Re: Rosehill Recycled Water Scheme (MP 07_0121)-Modify Major Project
(07-0121)

I refer to "Modification 1-Fairfield Park to Woodville Road route modification" that was part of the request to modify a major project that I lodged on 21/08/2009.

Figure 2-2 Distribution system overview including modification

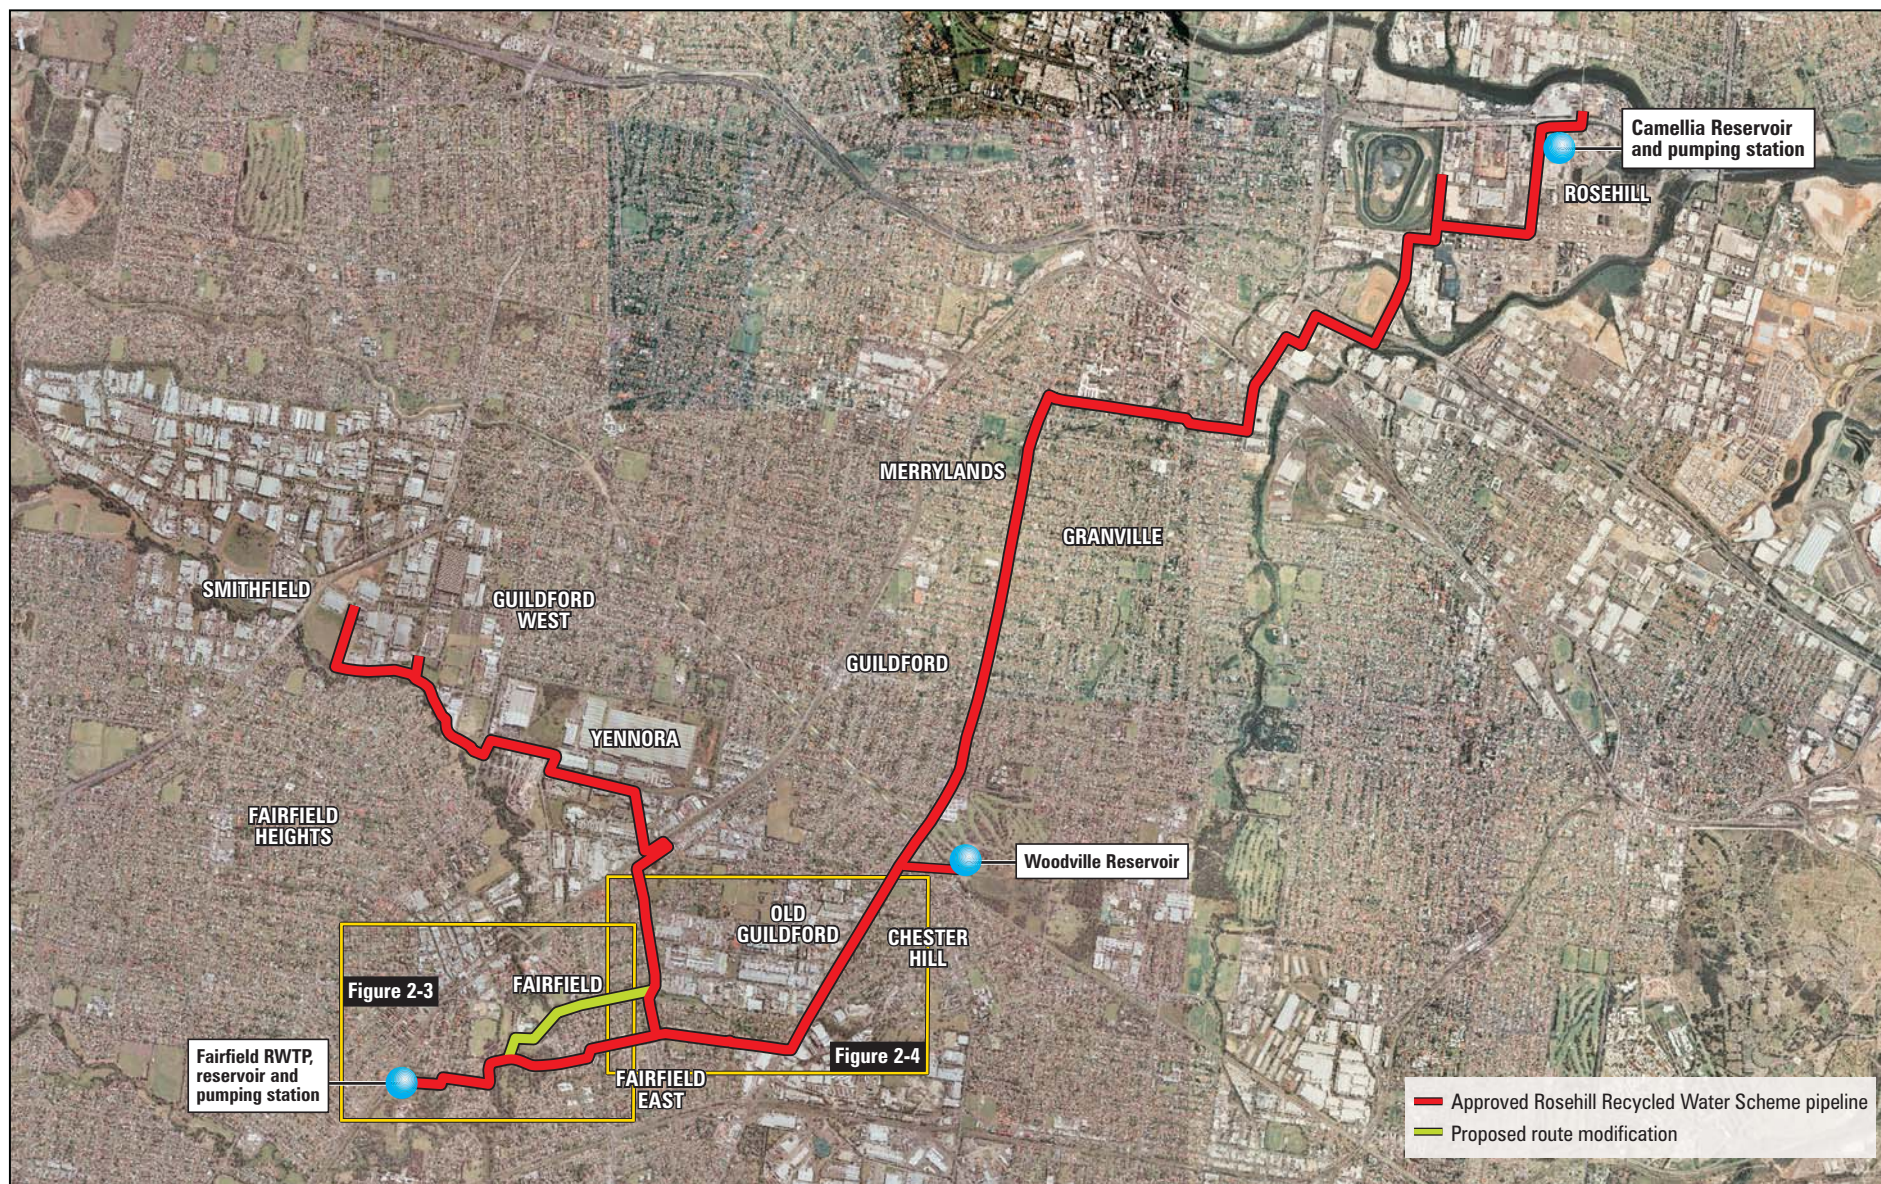
Please be advised that this modification has been further changed in the documents delivered to the Department on 17/02/2010, this change relates to retaining the deviation from Fairfield Park to where Langdon street meets Normanby Street and the deletion of the Malta Street section from Normanby Street to Woodville Rd.

At Normanby Street the water main will connect into the existing approved main with water going north in Normanby Street to the Smithfield customers and South in Normanby Street to joint the original route to Rosehill.

This change eliminated the need to drill under Burns Creek on Malta Street.
